CITY OF ALBUQUERQUE

June 30, 2020

Re: The Lamp Shop
1310 Cuesta Abajo Ct NE
Traffic Circulation Layout
Architect's Stamp 06-29-2020 (D16-D002J)

Traffic Circulation Layout
SCALE: 1" = 20'

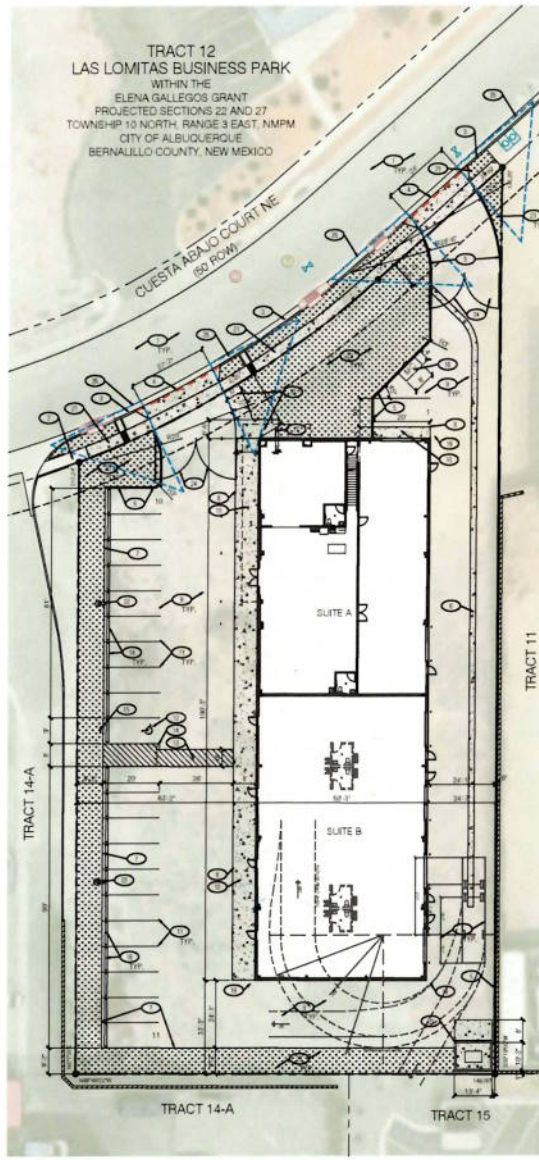
1. Please coordinate all calculations for parking spaces, including bicycle and motor cycle parking with Zoning and list the number required (If applicable).

2. Sidewalk will be needed on the public frontage of proposed development. The keyed note used (21) for this reference is incorrect, please adjust. Reference COA std dwg 2430 and provide width of proposed sidewalk. Provide a note on the east side of project where sidewalk ends that a tie slope of 5:1 to exist surface will be provided.

3. The proposed driveways will need to be call out and reference COA std dwg 2425 and the detail section.
4. The keyed note 23 is being called out as Pole light on concrete base and refer to detail A2/TCL but it is shown as landscaping. This needs to be clarified what is being proposed.

5. Keyed note 24 is for landscaping planter area but you have shown as the entrance gates. Please adjacent this concern.
6. Keyed 19 references detail C2-TCL but there is no detail provided. Please provide detail of proposed bollards and **paint bollards yellow**.

7. Keyed note 22 points to light pole but references another item. Please correct this issue.
8. Please list the **width** and length for all proposed parking spaces. Some dimensions are not shown.

10. Why not provide motorcycle parking stall in the same area of all proposed parking stalls (**SUGGESTION ONLY**).
11. The ADA accessible spaces must include an access aisle. Van accessible aisles should be **8ft wide**; all others should be 5ft wide. Label on TCL site plan.

12. The proposed 6ft wide ADA accessible pedestrian pathway is adjacent to the proposed driveway. Is there any conflict between the driveway and the 6ft pathway in the way of ADA accessible? Please clarify.

13. ADA accessible pedestrian pathway should not be placed behind parking space or adjacent to a vehicular way. Vehicle and pedestrian/wheel chair conflicts should be avoided as much as possible. This occurs on the west side of building. Provide curbing or a barrier between pathway and vehicular traffic flow. This is based on Keyed note 8 versus 6ft ADA pedestrian pathway.

14. All sidewalks along streets should be placed at the property line (**If applicable**).
15. Curbing should be installed to **delineate landscape, parking, and pedestrian ways** and identify points of access. Please call out detail and location of barrier curb.
